From: Tim Murray [REDACTED]
Sent: 08 July 2020 17:08
To: Sian Eggington
Subject: RE: Request for further information FP/102/20/HH
Attachments: We sent you safe versions of your files; Westmorland Drive 2-BLOCK PLAN.pdf
Categories: Green Category

DRAWING BLOCK PLAN DATE: JUNE 2020 DRAWN: T. Murray	SCALE 1/500
DRAWING: 20/35/3	REVISION:

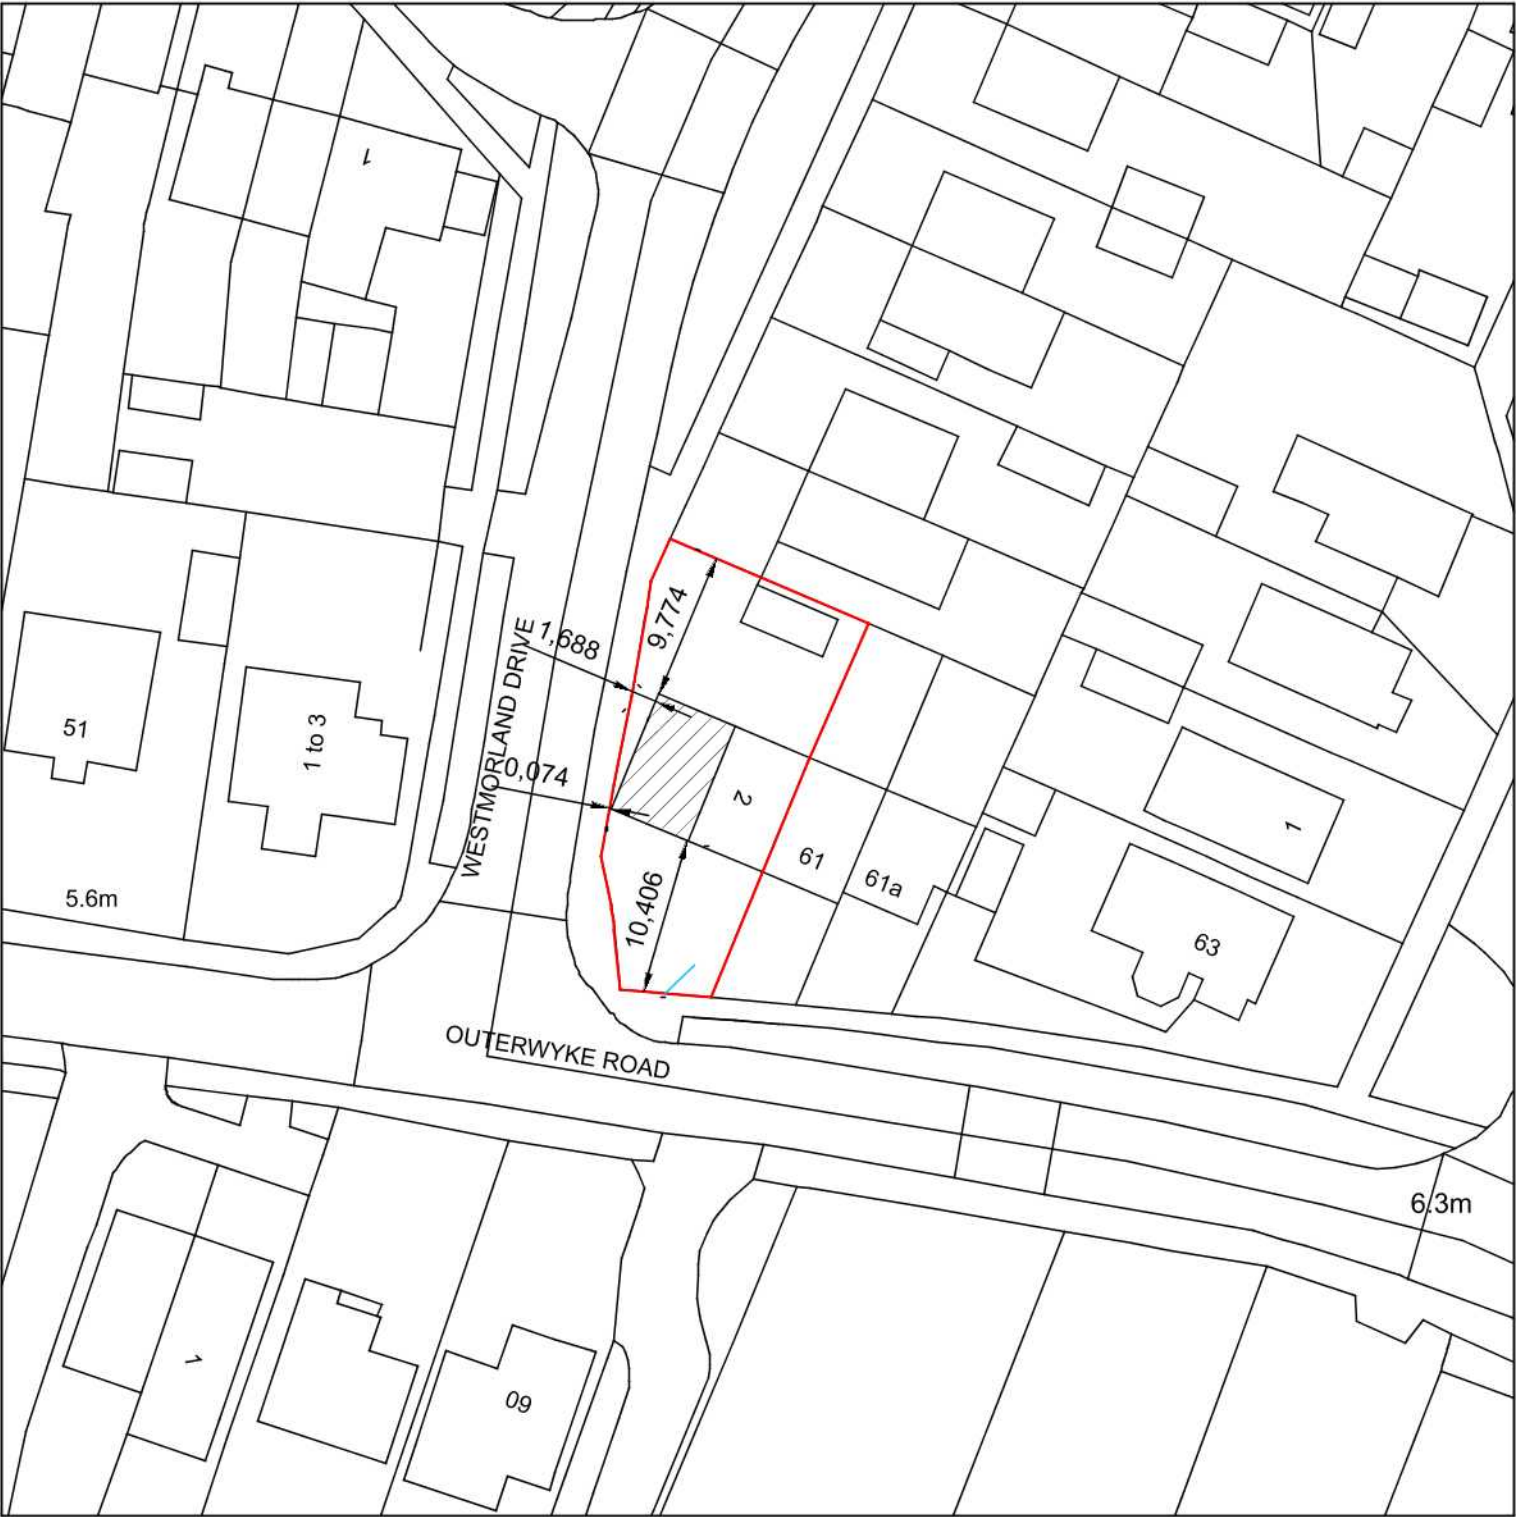
The Block plan is showing a proposed crossover, please confirm whether this is proposed and being applied under this application or is existing. If a new crossover is being proposed this will need to be added to the description. With your permission we can add this for you. A splay plan will also need to be provided with dimensions of the crossover (width and depth) included.

I have spoken to the client who informs me that it is intended to access the proposed garage by means of the existing crossover from Westmorland Drive, and accordingly I attach revised block plan with reference to proposed new vehicle access deleted.
